From: Fiona Fitzgerald <Fiona.Fitzgerald@arun.gov.uk>
Sent: 19 November 2020 20:52
To: Planning.Responses <Planning.Responses@arun.gov.uk>; Chris McConnell [REDACTED]
Cc: Raymond Cole <Raymond.Cole@arun.gov.uk>
Subject: F/4/20/OUT

Further to our conversation last week, I have reviewed the documents submitted in F/4/20/OUT. My comments are below:

Figure 4: Typical illustrative plan showing noise mitigation principles, subject to detailed noise assessment and layout planning at reserved matters stage. Not for approval of detailed block layout or type/mix of housing.

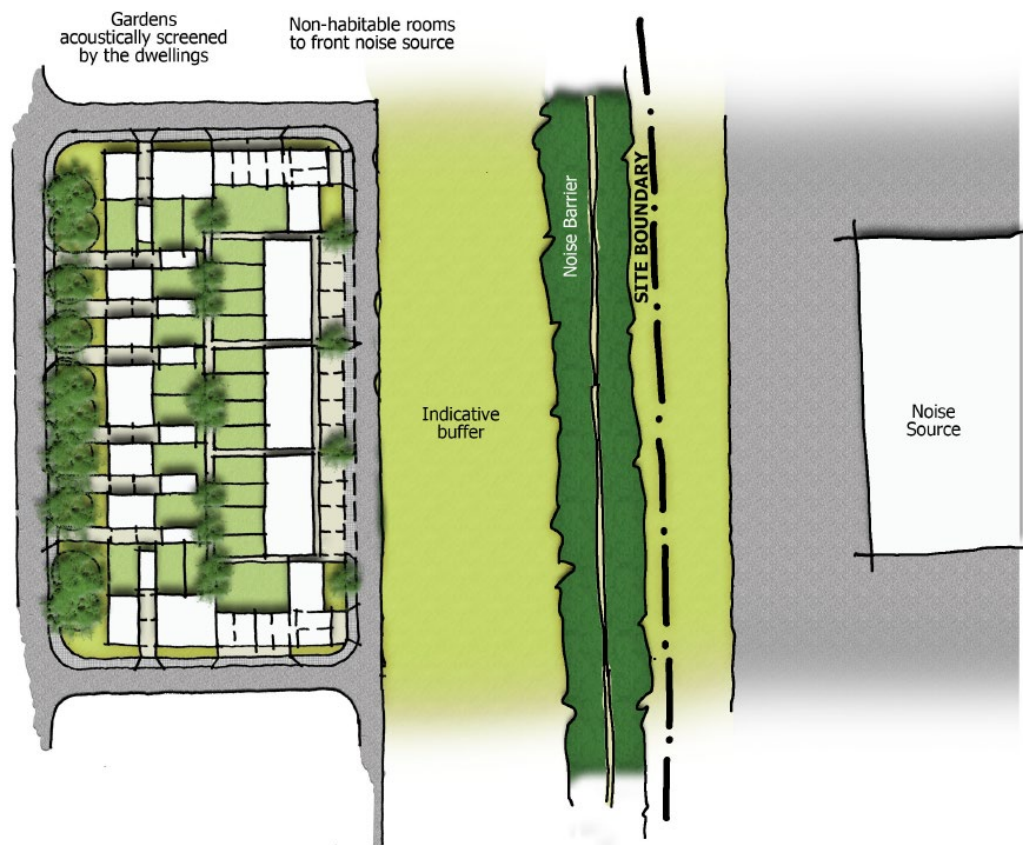
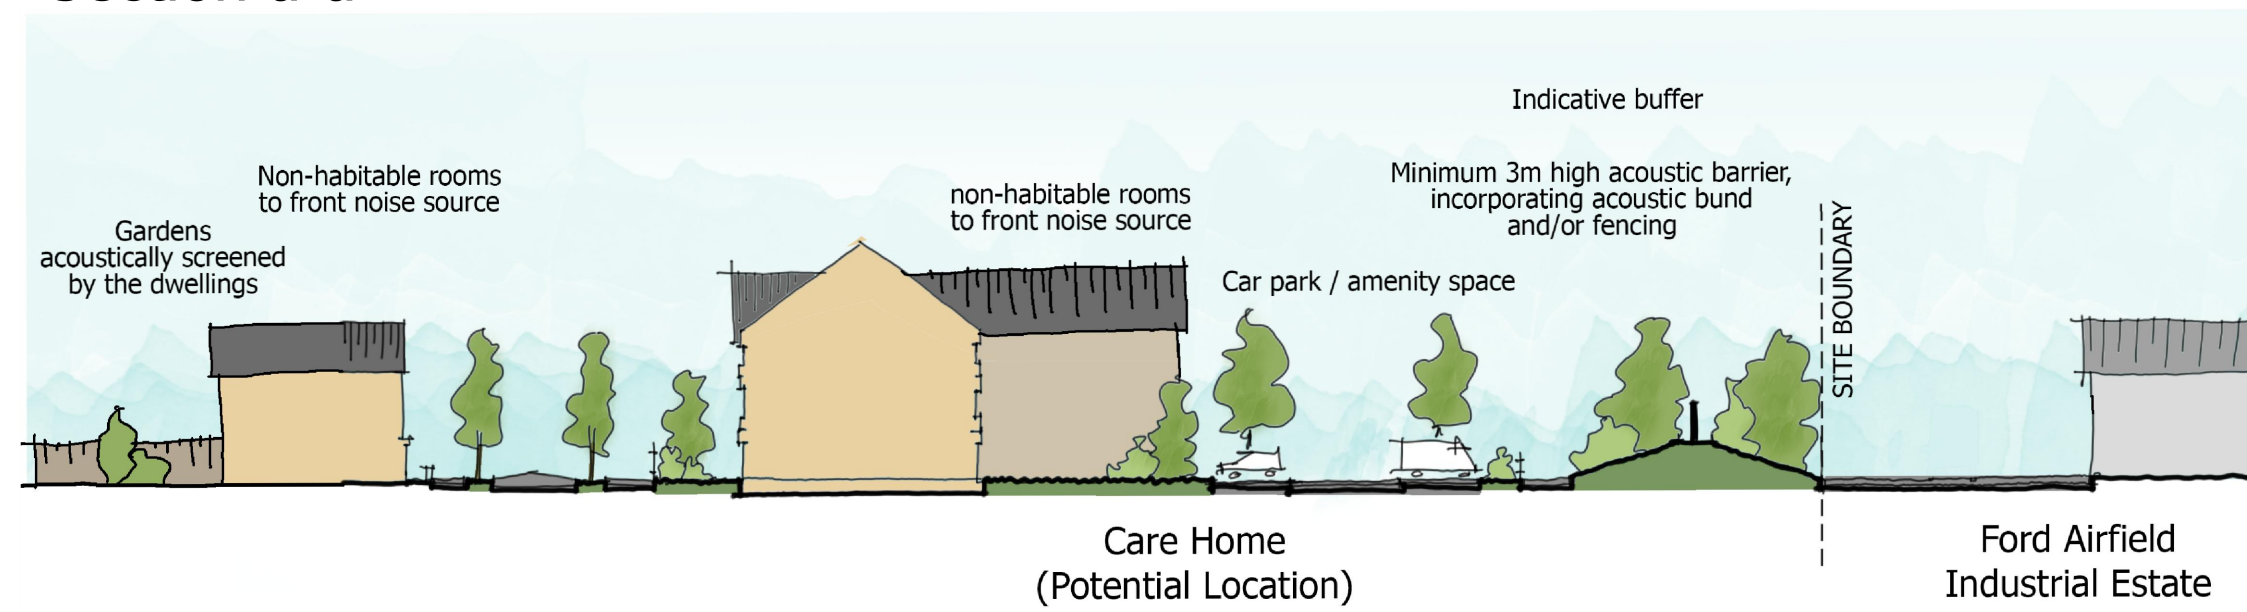
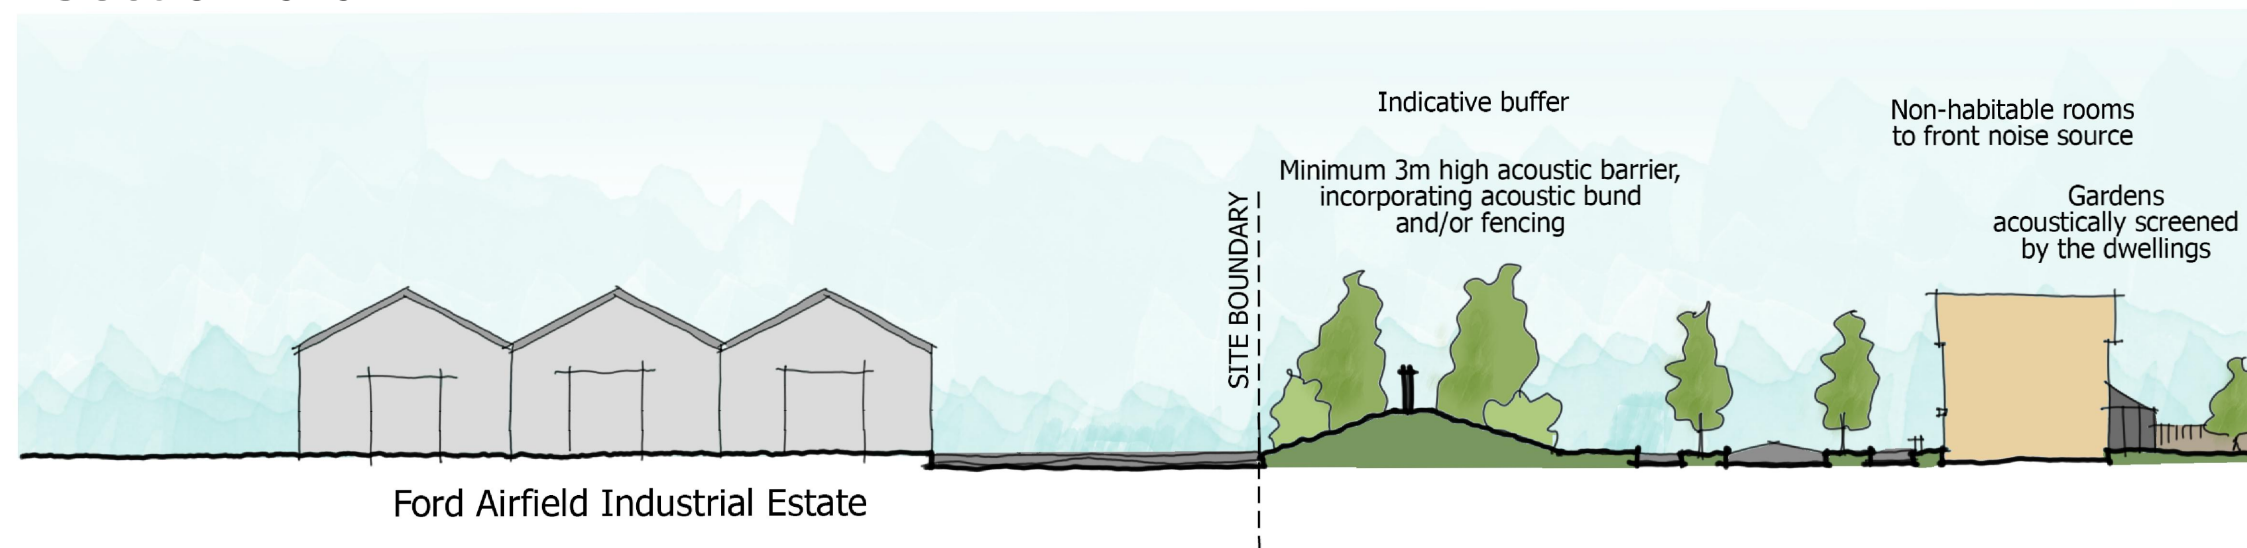
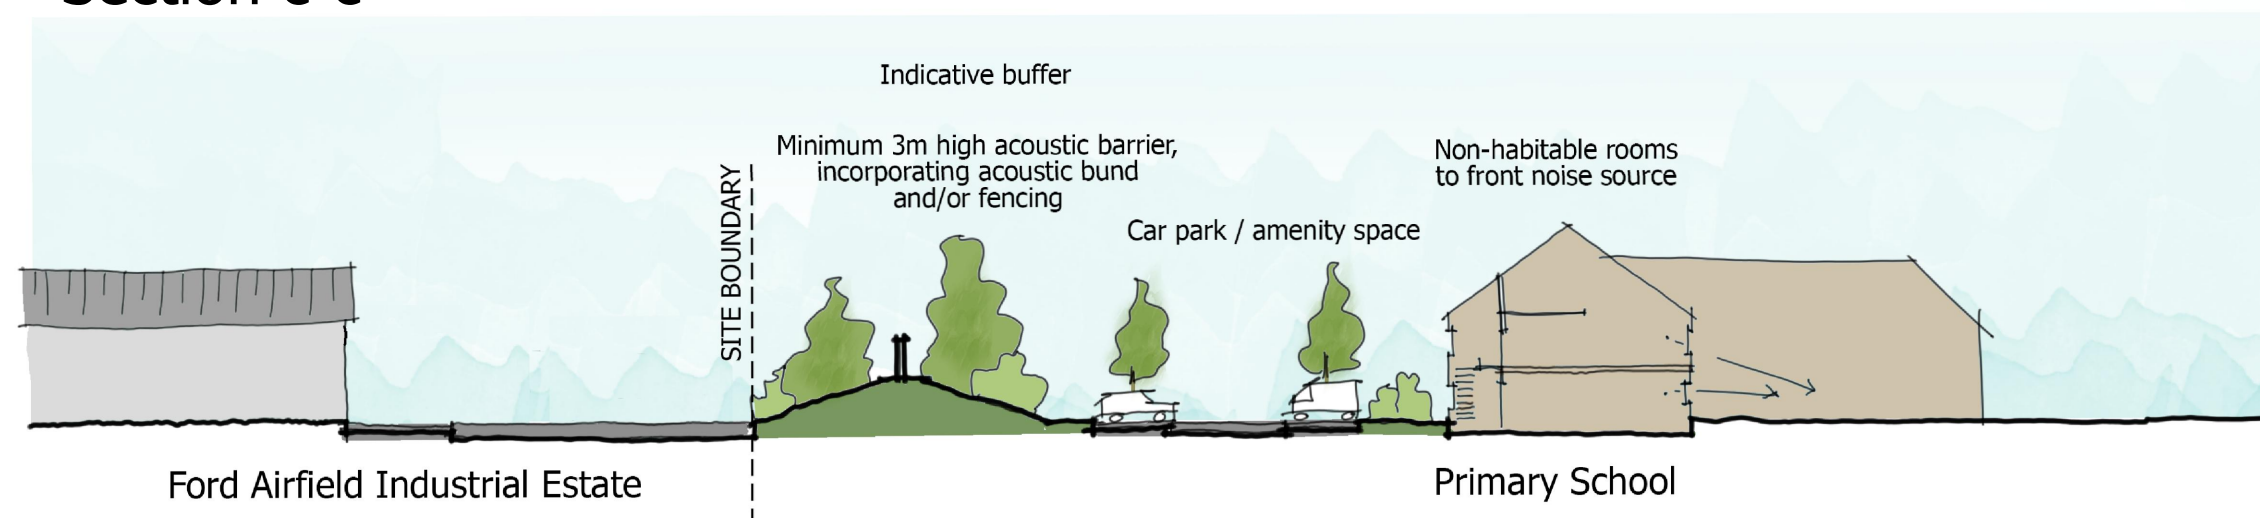
In terms of dwellings facing Yapton Road and Ford Lane there is no indication of how many dwellings would require the mitigation and to what extent and therefore it is not possible to make an adequate assessment of the likelihood of impact on amenity as it is not known how many of the dwellings will be affected.

With regard to dwellings to the north of Ford Industrial Estate, Environmental Health remains of the opinion that a rating of +10dB, as it is considered to generate a significant adverse impact, is not acceptable, even with mitigation as described.

The acoustic report states that it is 'anticipated' that noise levels within gardens would be in the order of 50-55dB but this is not certain and therefore it is considered that insufficient information has been provided to allow this assessment to be made.
